**KIRKLEES METROPOLITAN COUNCIL
INVESTMENT & REGENERATION SERVICE**

Reference No:	2023/62/92608/W
Site Address:	Carr Lea House, 56, Rawthorpe Lane, Dalton, Huddersfield, HD5 9NU
Description:	Change of use from one dwelling to two dwellings
Recommending Officer:	William Simcock

DECISION – Conditional Full Permission

Officer Report – 2023/92608

SITE ARRANGEMENT PLAN.
SCALE 1:200.

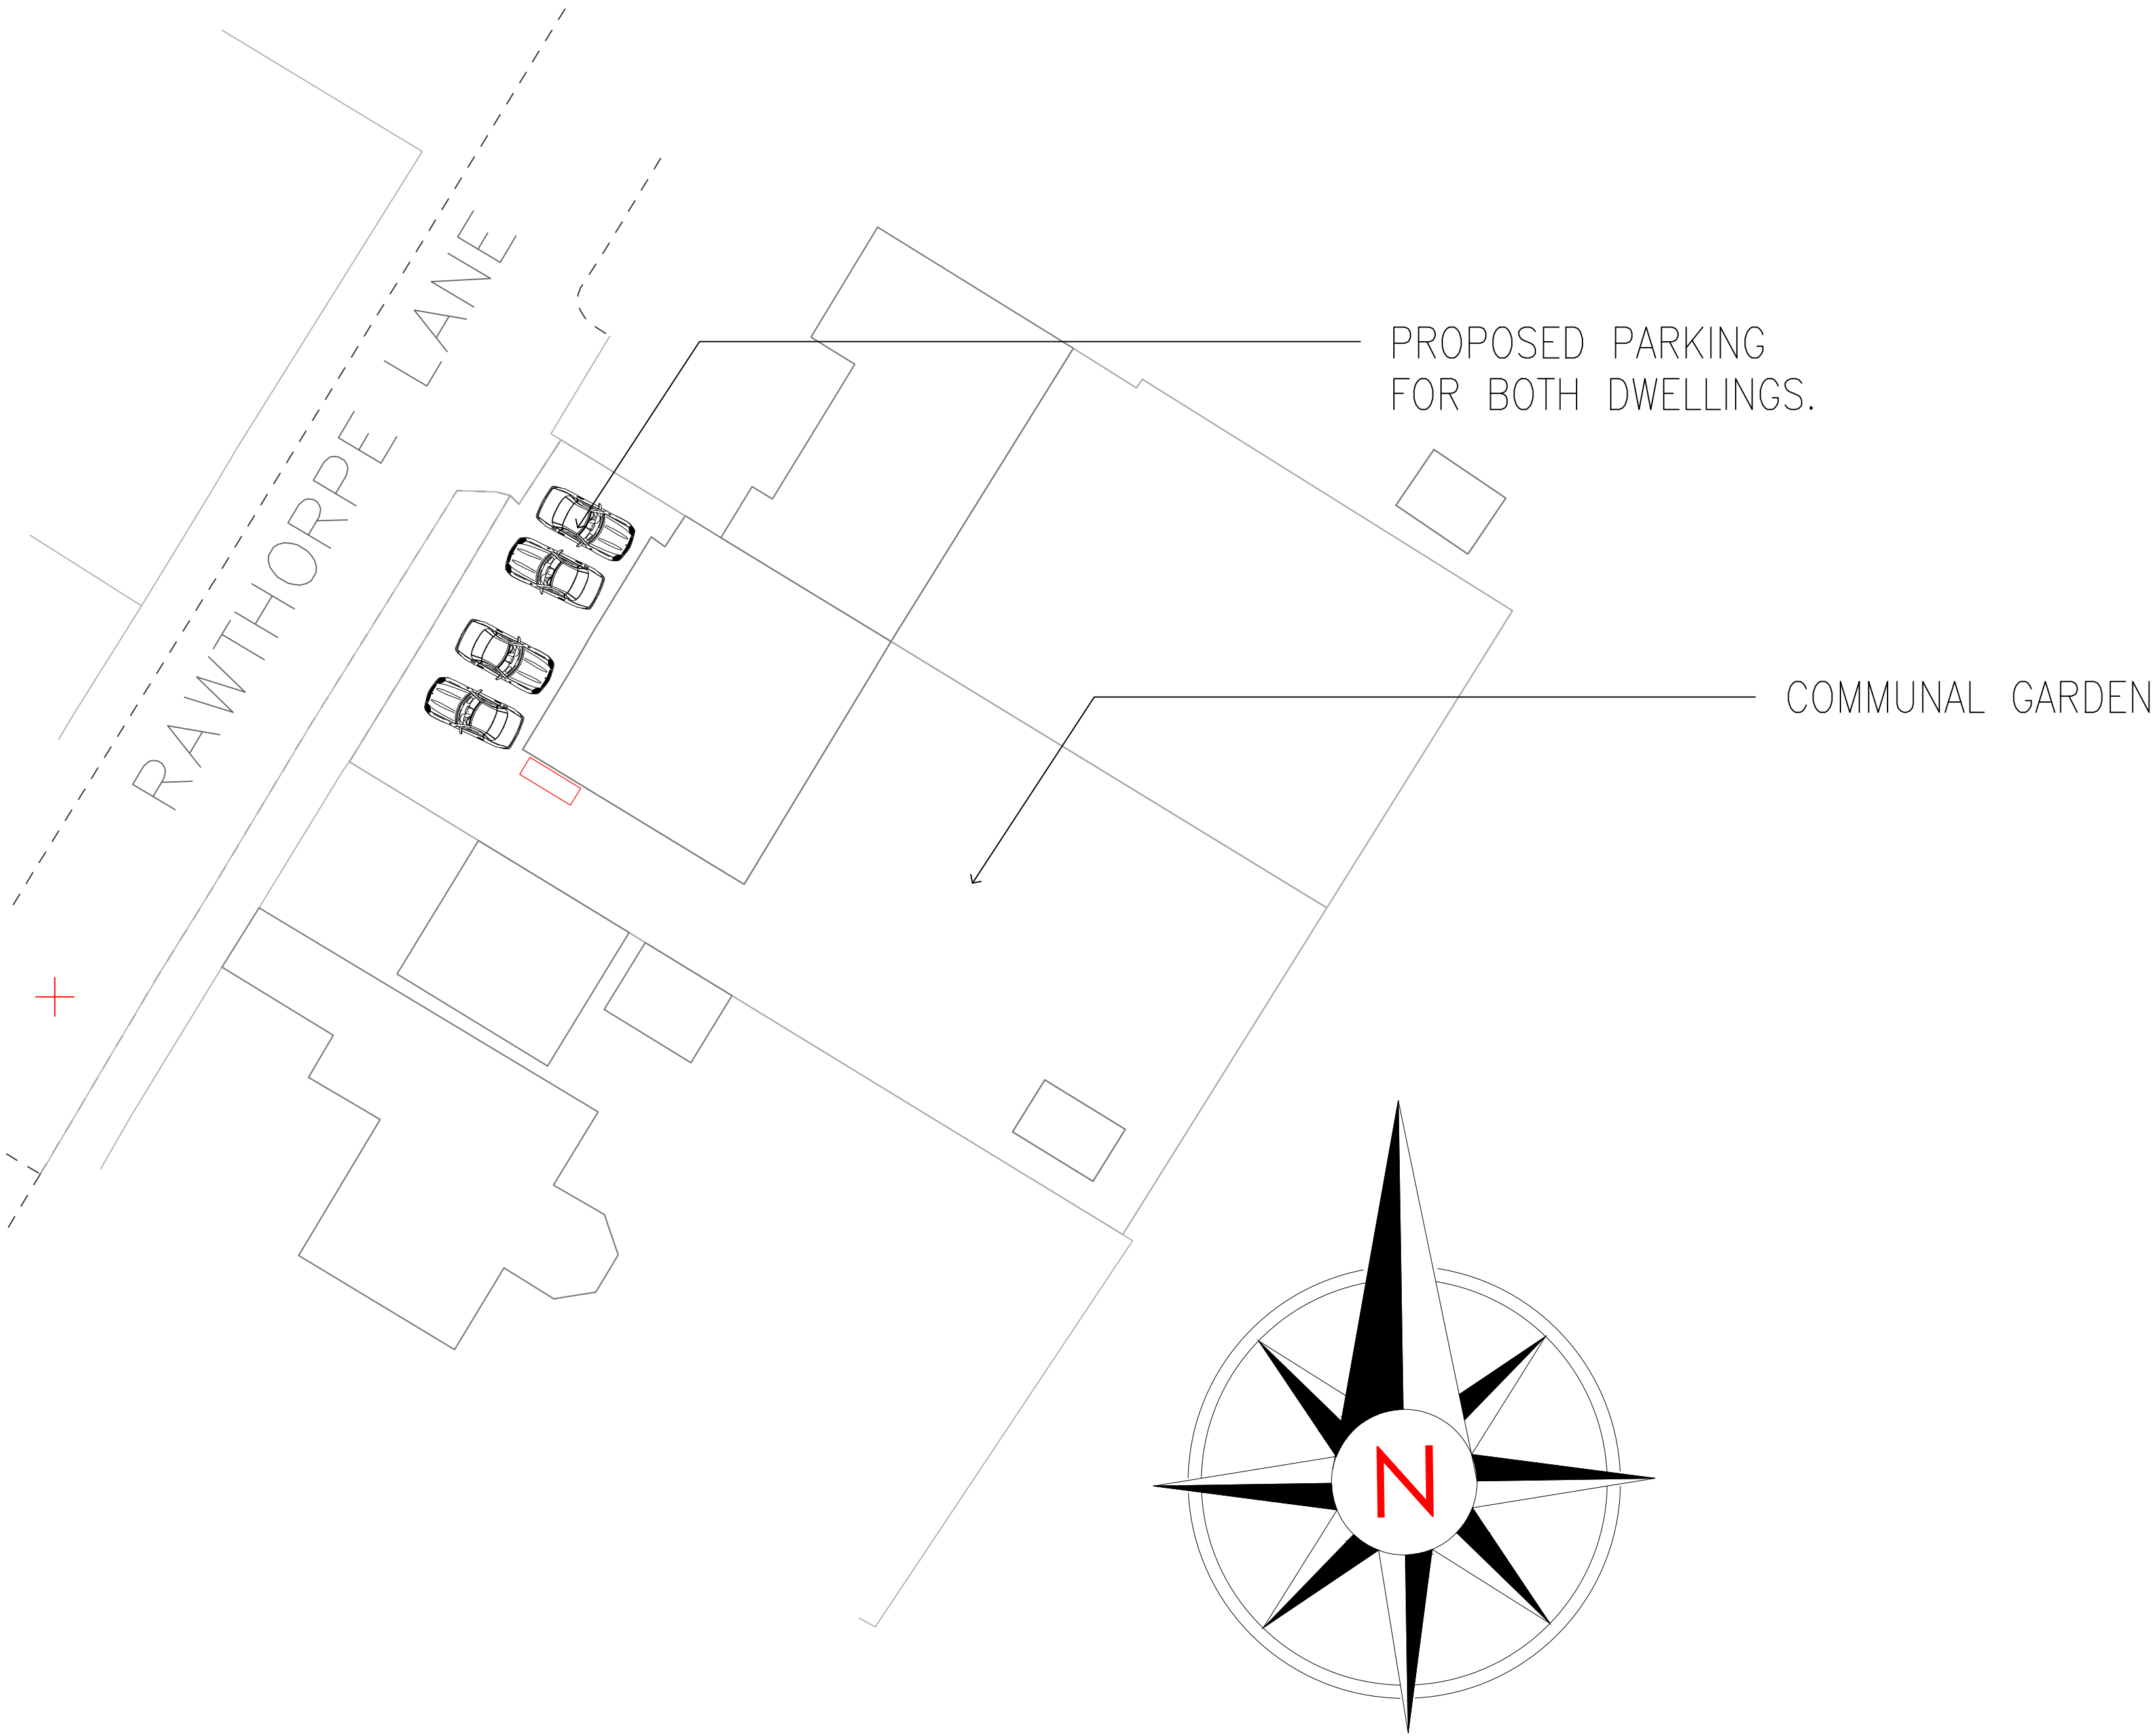
According to the application form, five parking spaces would be provided within the site (unchanged from existing situation). Subsequently this has been clarified as four, which are shown on the plans.

The bedroom window in the ground floor flat would look out on to the parking spaces allocated to the development. The living room windows would also look out on to an area that is used for the parking of vehicles, but this will be principally for pick-up and drop-off and not long-stay parking, and was not heavily used at the time when the case officer visited the site. It is therefore considered that the rear outlook for occupants of this flat would be acceptable.

The proposed dwellings would not have access to private amenity space. The land to the rear is annotated as “communal garden” but, in reality, most of this is hard-surfaced land used for the parking and turning of vehicles; there is a small retained area of garden at the eastern end of the site but there is no clear means of access to it. The provision of useable private amenity space is

4 – Impact on highway safety: The development takes access to a non-classified road. Means of access to the highway would be unchanged. The access and local highway network are considered to be of a sufficient standard to take on additional traffic associated with the development. The latest plan shows that four parallel parking spaces would be provided along the frontage. This could be allocated as one for the single-bedroom flat, three for the two-storey dwelling, thereby providing parking at the rate recommended in the Highway Design Guide.

4A Refuse collection: The plans do not explicitly set out an area for the storage and collection of wastes. There is however a rectangle marked in red on the site plan which could fulfil this function. Since the proposal is not likely to result in a significant increase in the amount of waste generated, it is considered that it can be determined without further details being supplied and that it would be in accordance with the aims of Policy LP24(d)(vi).

3. The areas to be used for the parking of vehicles associated with the development as shown on the approved site plan shall be retained as such and free of any obstruction to that use.
